From: Will Conway <wconway@sebagotechnics.com>
To: Rico Spugnardi <RSpugnardi@pwd.org>
CC: David Margolis-Pineo <dmp@portlandmaine.gov>, Helen Donaldson <HCD@portlandmaine.gov>, Mark Lozoraitis <mLozoraitis@sebagotechnics.com>
Date: 10/1/2013 5:09 PM
Subject: RE: Seaport Lofts Storm Drain

From: Rico Spugnardi [RSpugnardi@pwd.org]
Sent: Tuesday, October 01, 2013 3:42 PM
To: Will Conway
Cc: David Margolis-Pineo
Subject: RE: Seaport Lofts Storm Drain

Hi Rico, we had sent plans over for your review (regarding its proximity to your water main), and the Planning Department is asking us for either your approval - or if you want us to make any changes...any chance you can have a look soon ?

SITE PLAN
 OF
SEAPORT LOFTS
 NEWBURY/HANCOCK STREET
 PORTLAND, MAINE
 FOR:
113 NEWBURY STREET, LLC
 35 FAY STREET, SUITE 107B
 BOSTON, MA 02116-4520

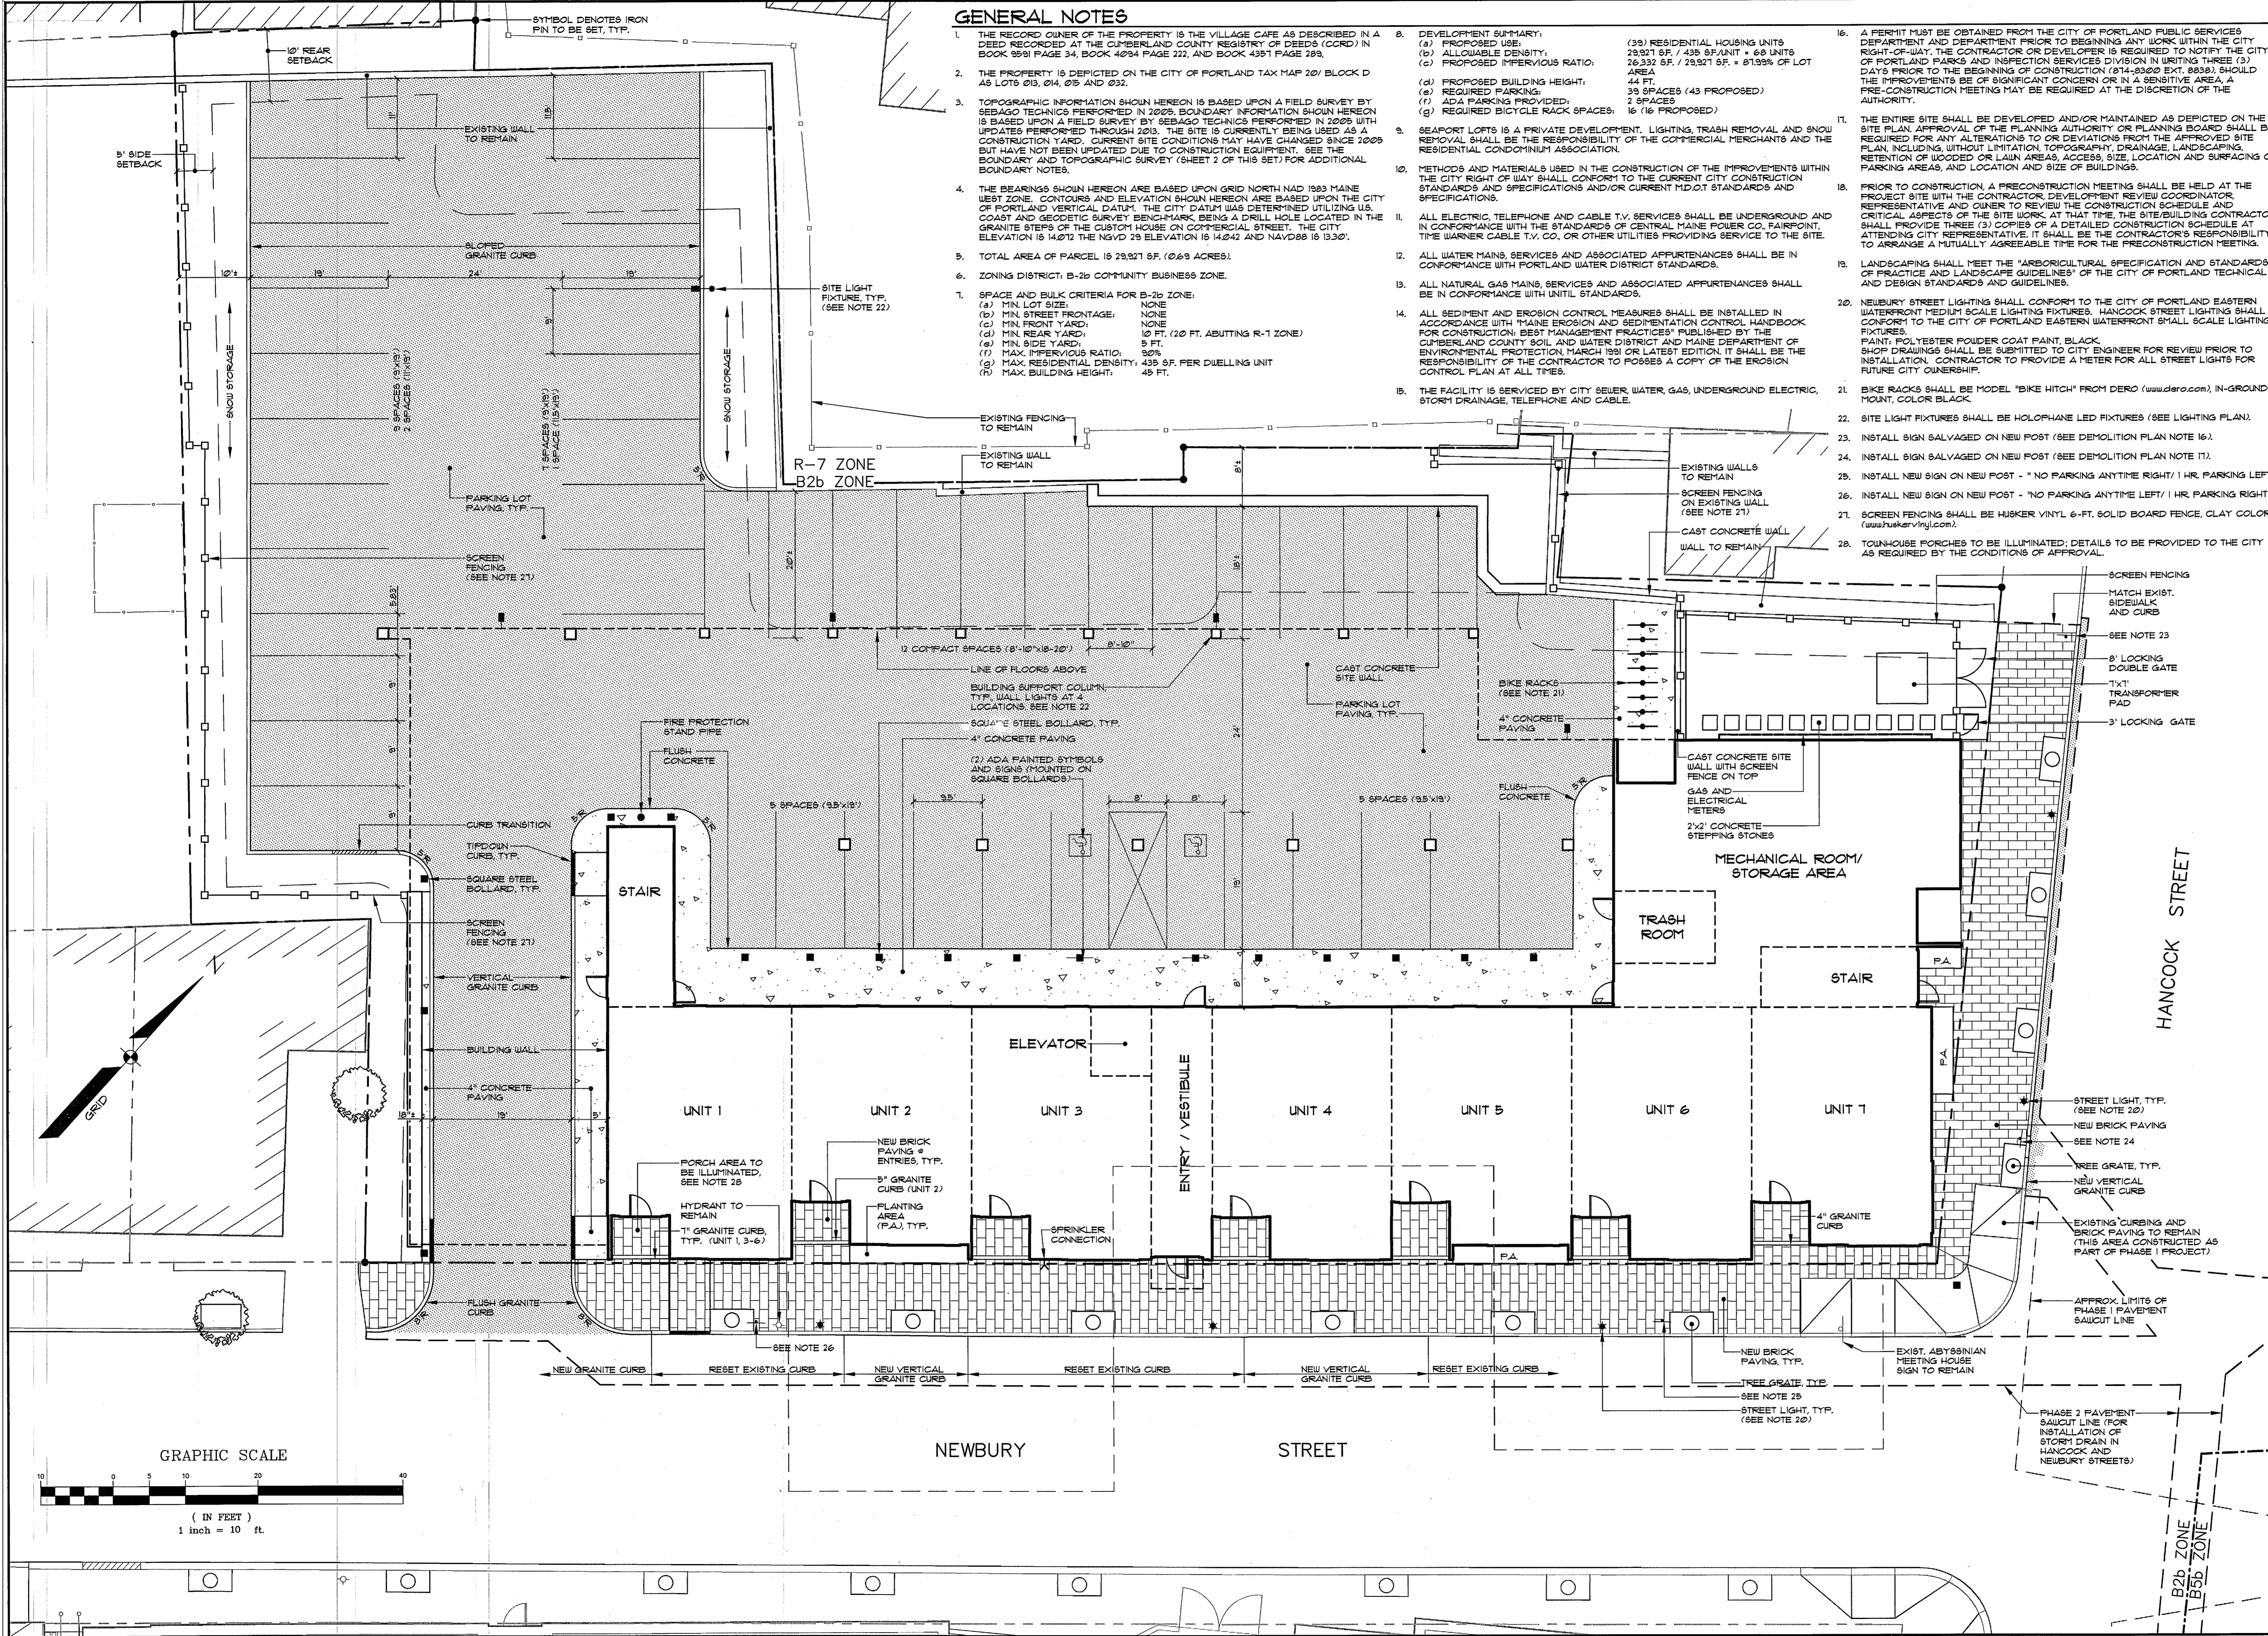
- 2) Unrelated to the storm drain design but relevant to water service is the proposed location of the mechanical room on the plan. The services look to enter the building at the basement of Unit 2. Yet the mechanical room is located on the other side of the lot. Are there plans yet of how the internal piping will work? PWD does not typically allow a meter location that far away from the building entrance, as it would be very easy to tap before the meter. Just curious if that has been worked out with the development team. We don't have a mechanical engineer on board yet, so we'll have to address this when we do. We will at that time coordinate the meter location.

**BOUNDARY & TOPOGRAPHIC SURVEY**  
 OF:  
 SEAPORT LOFTS  
 NEWBURY / HANCOCK STREET  
 PORTLAND, MAINE  
 FOR:  
 113 NEWBURY STREET, LLC  
 35 FAY STREET, SUITE 07B  
 BOSTON, MA 02118-4920

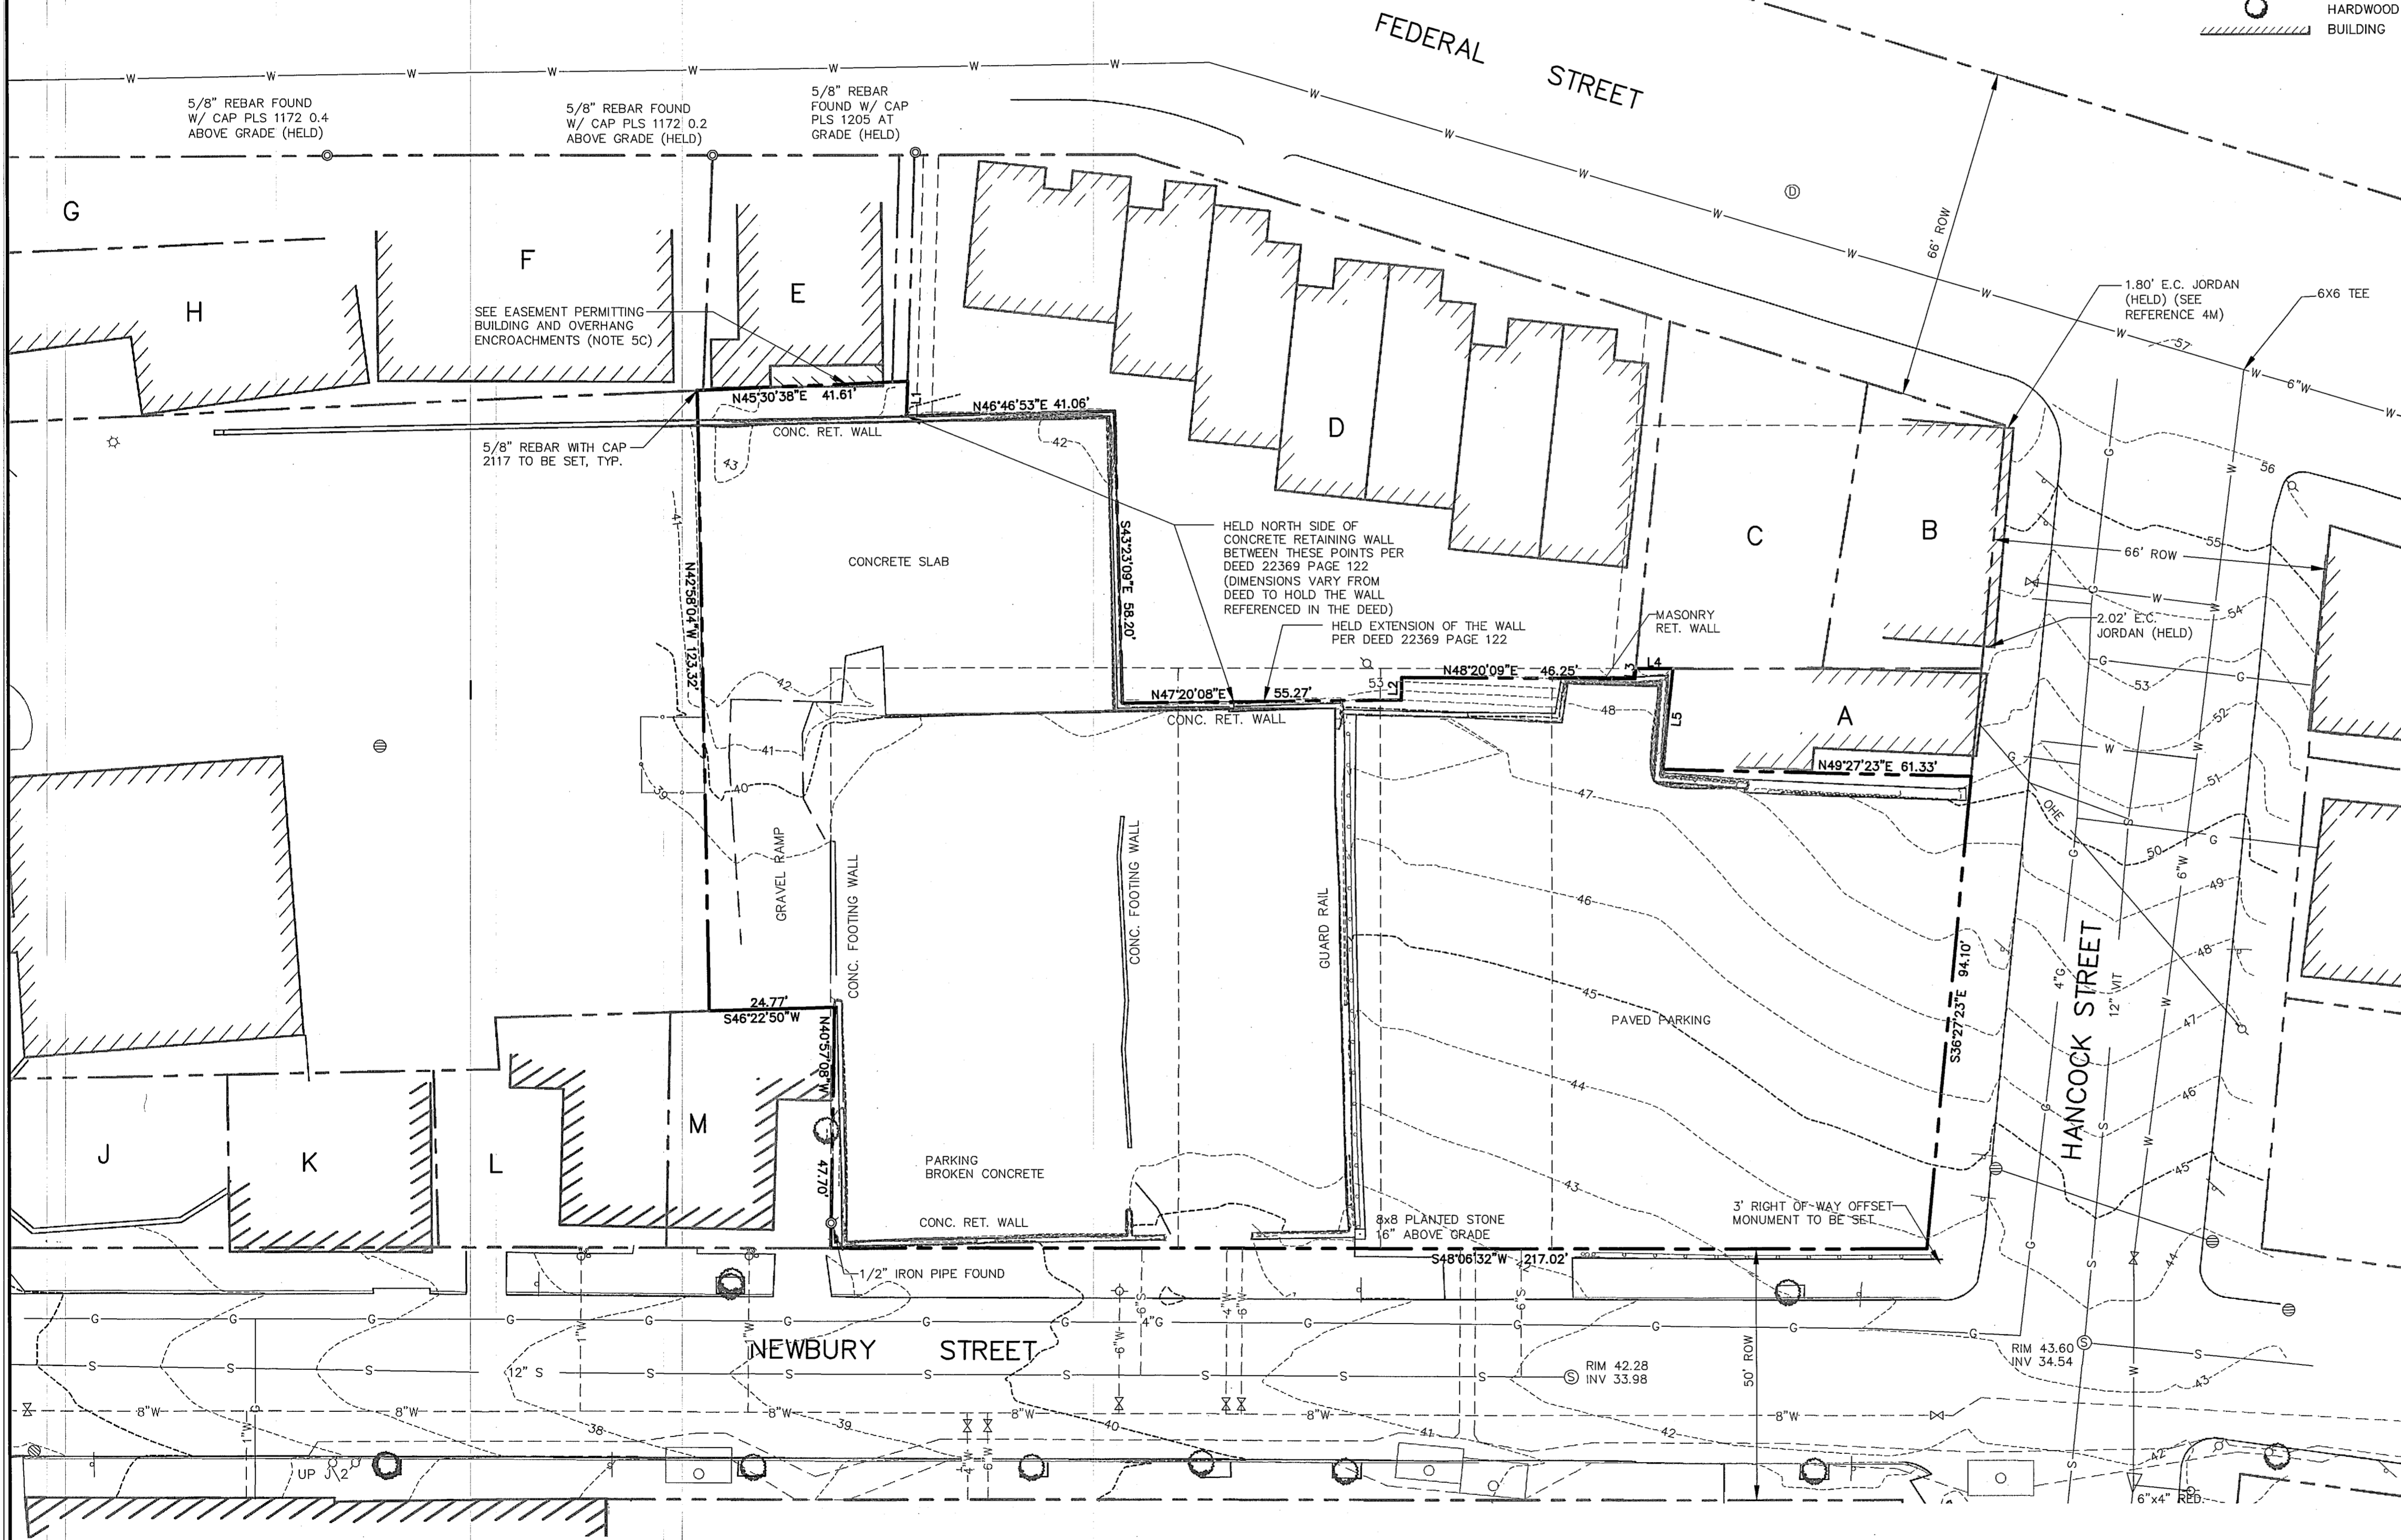
- 1) The survey plan looks to show design information from the water main renewal on Newbury Street that occurred this year. Would it be possible to show as-built information? The only critical pieces are the two service lines entering the new site and the new hydrant. The survey plan shows the hydrant as being located on the south side of Newbury Street, when in reality it was installed on the north side. Without that exact locational information, I can't tell if there will be a conflict between the new 4-inch underdrain and the hydrant. The service locations appear correct, but it would be helpful to know exactly where they enter the site to see if there are conflicts. I'll check but I think we did use as built data...except for the hydrant, we'll fix that.
